# SPRINGS AT WATERVIEW PRELIMINARY PLAN

LOCATED IN THE NW 1/4 OF SECTION 7, T15S, R65W OF THE 6TH P.M.,  
EL PASO COUNTY, STATE OF COLORADO

SHEET TITLE TITLE SHEET

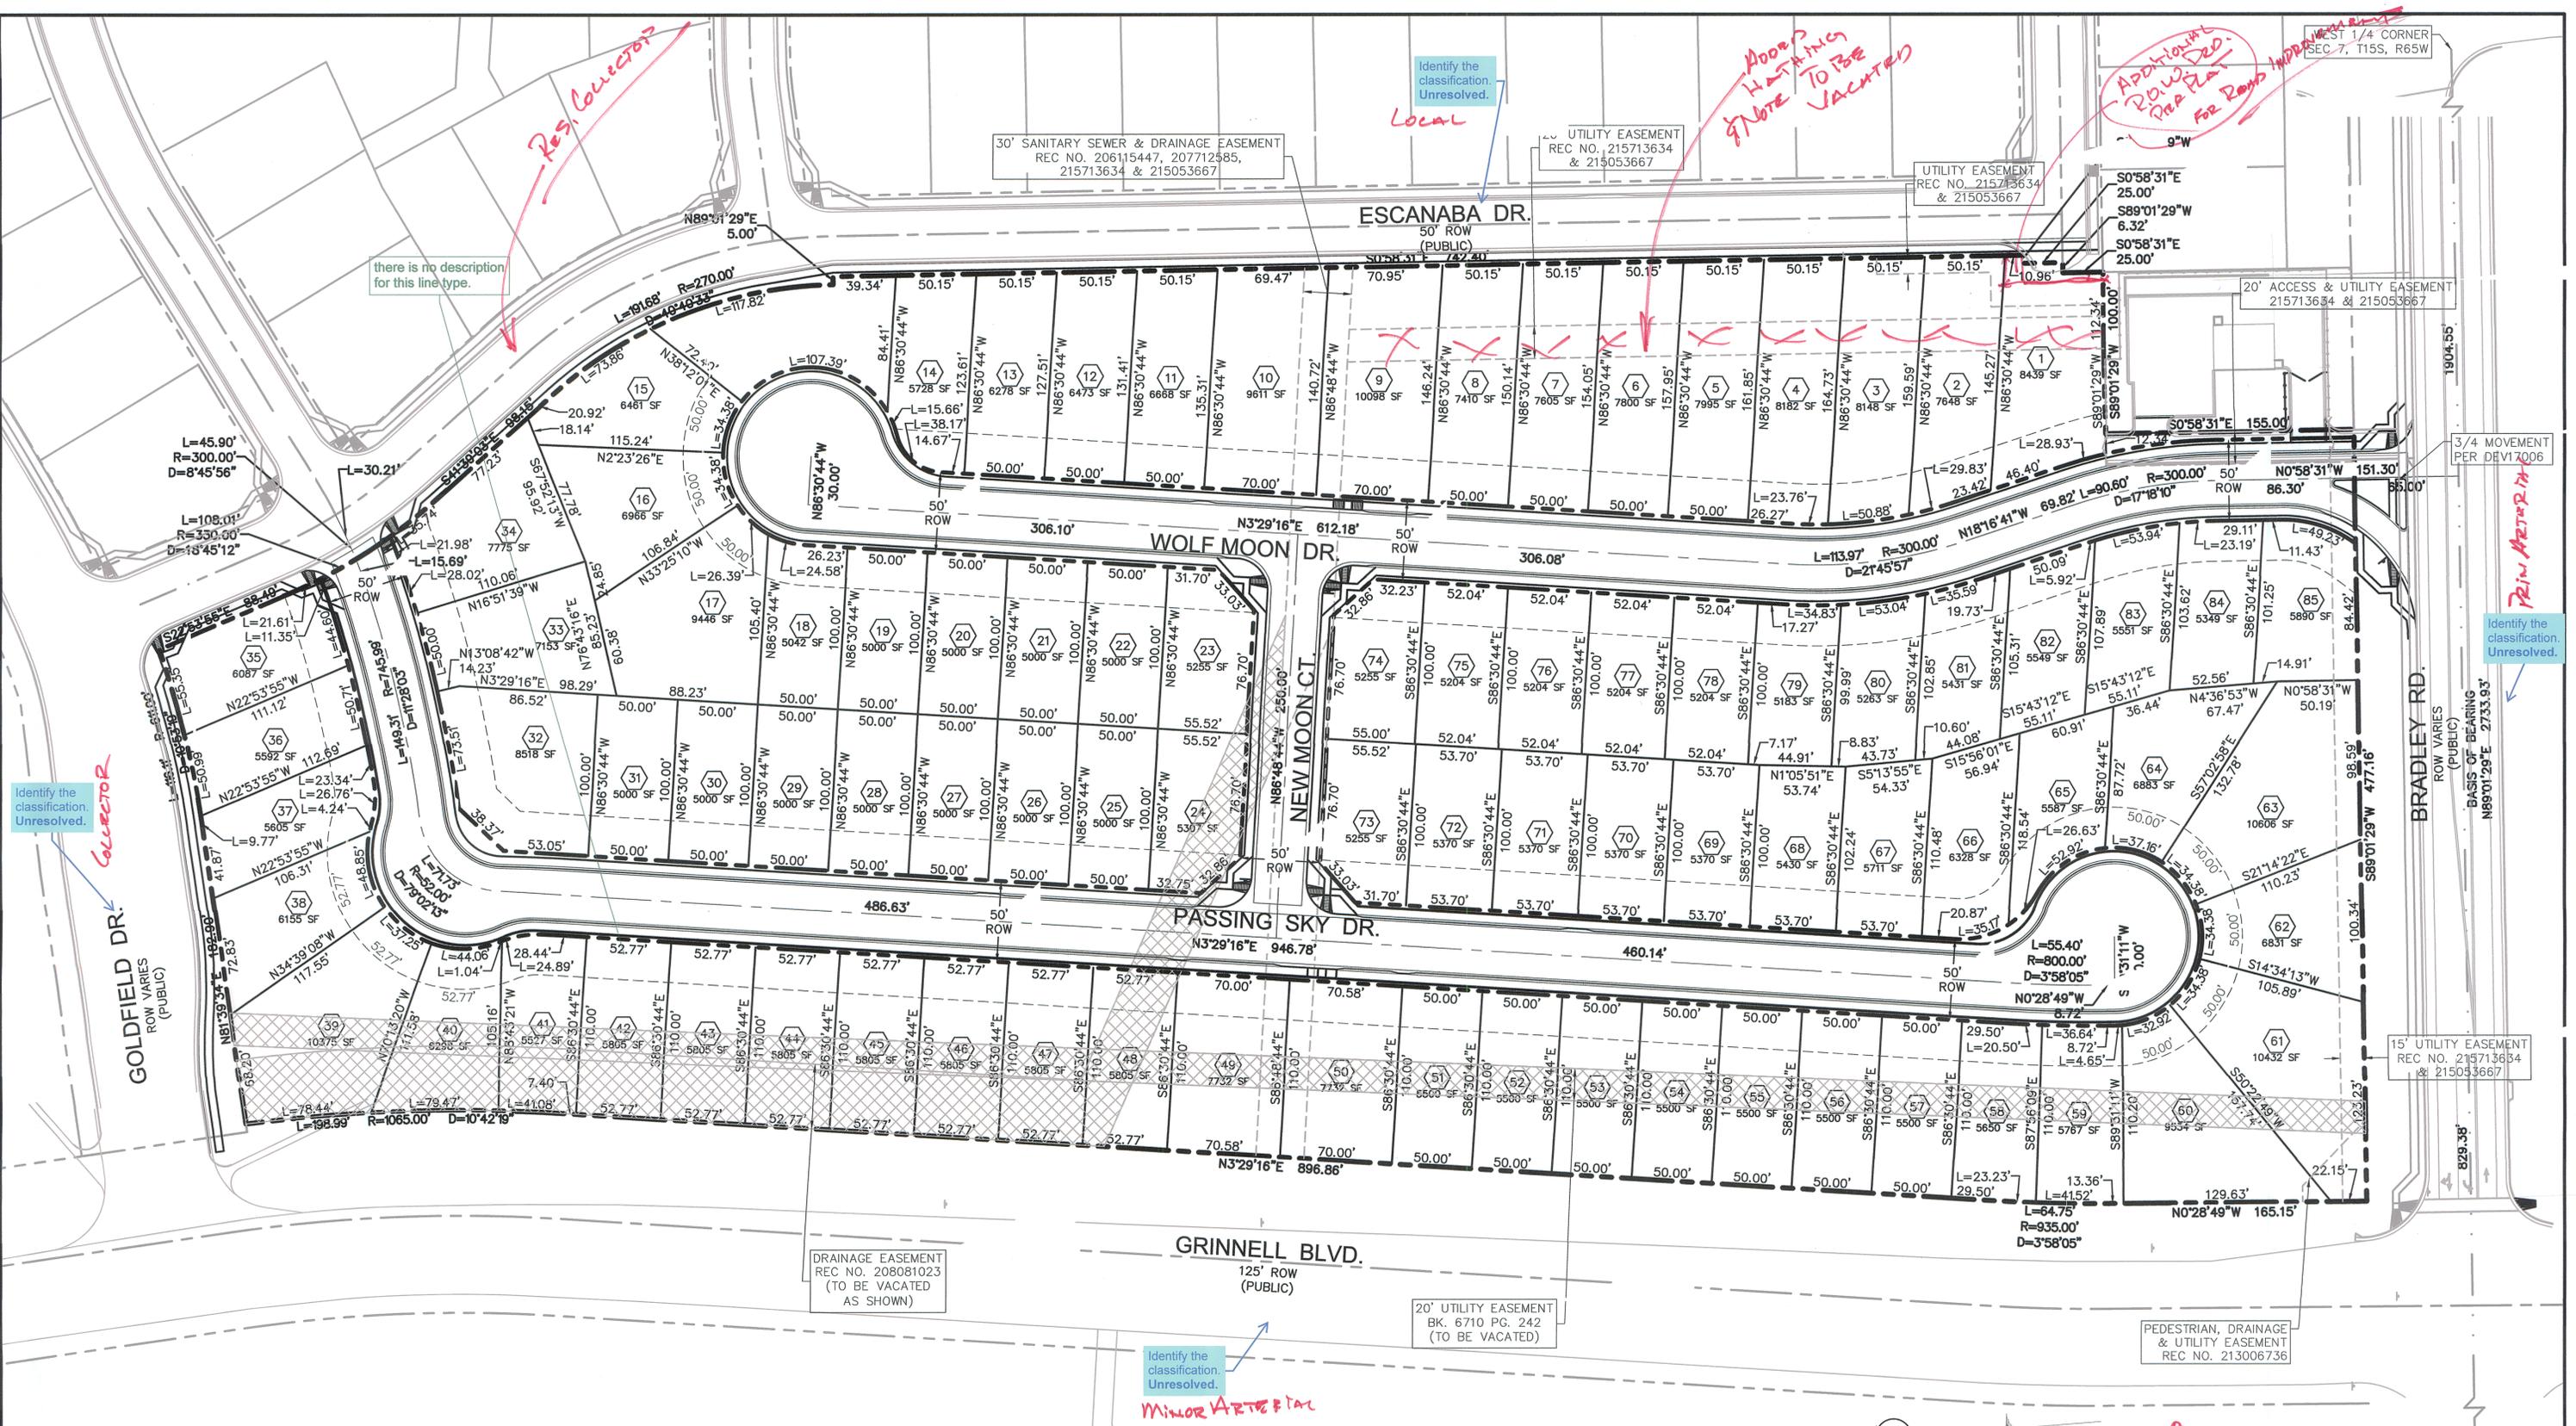
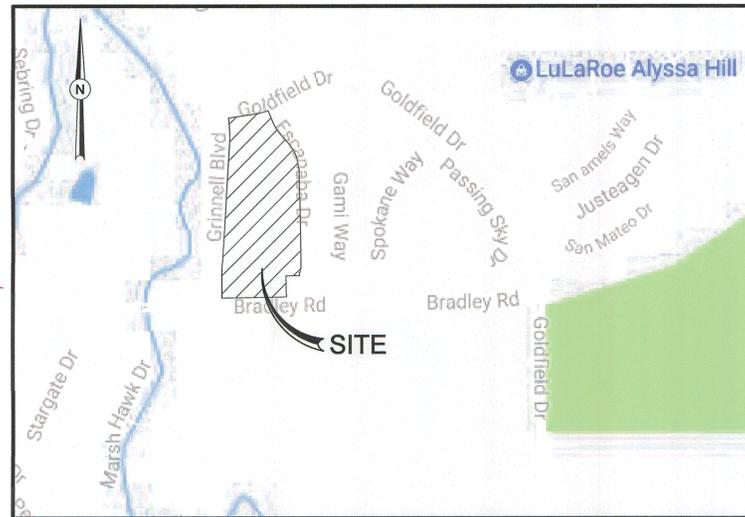
- NO PART OF THIS PROPERTY FALLS IN THE 500 YEAR FLOOD PLAIN (EST. BY FEMA). Provide the specific FEMA FIRM Panel No. Unresolved.
- NOTWITHSTANDING ANYTHING DEPICTED IN THESE PLANS IN WORDS OR GRAPHIC REPRESENTATION, ALL DESIGN AND CONSTRUCTION RELATED TO ROADS, STORM DRAINAGE AND EROSION CONTROL SHALL CONFORM TO THE STANDARDS AND REQUIREMENTS OF THE MOST RECENT VERSION OF THE RELEVANT ADOPTED EL PASO COUNTY STANDARDS, INCLUDING THE LAND DEVELOPMENT CODE, THE ENGINEERING CRITERIA MANUAL, THE DRAINAGE CRITERIA MANUAL, AND THE DRAINAGE CRITERIA MANUAL VOLUME 2. ANY DEVIATIONS FROM REGULATIONS AND STANDARDS MUST BE REQUESTED AND APPROVED IN WRITING TO BE ACCEPTABLE.

- THERE WILL BE NO DIRECT LOT ACCESS TO BRADLEY ROAD, ESCANABA DRIVE, GOLDFIELD DRIVE, AND ESCANABA BLVD. FROM ANY LOT OR TRACT. VEHICULAR ACCESS TO LOTS ABUTTING TRACT A IS NOT PERMITTED. Duplicate

- ALL SIGHT TRIANGLES WILL BE CREATED BY ROW DEDICATION. Add Grinnell Blvd.
- THIS DEVELOPMENT WILL PARTICIPATE EQUITABLY IN THE CONSTRUCTION OF A TRAFFIC SIGNAL AT GOLDFIELD DRIVE AND GRINNELL BOULEVARD.

This seems out of place
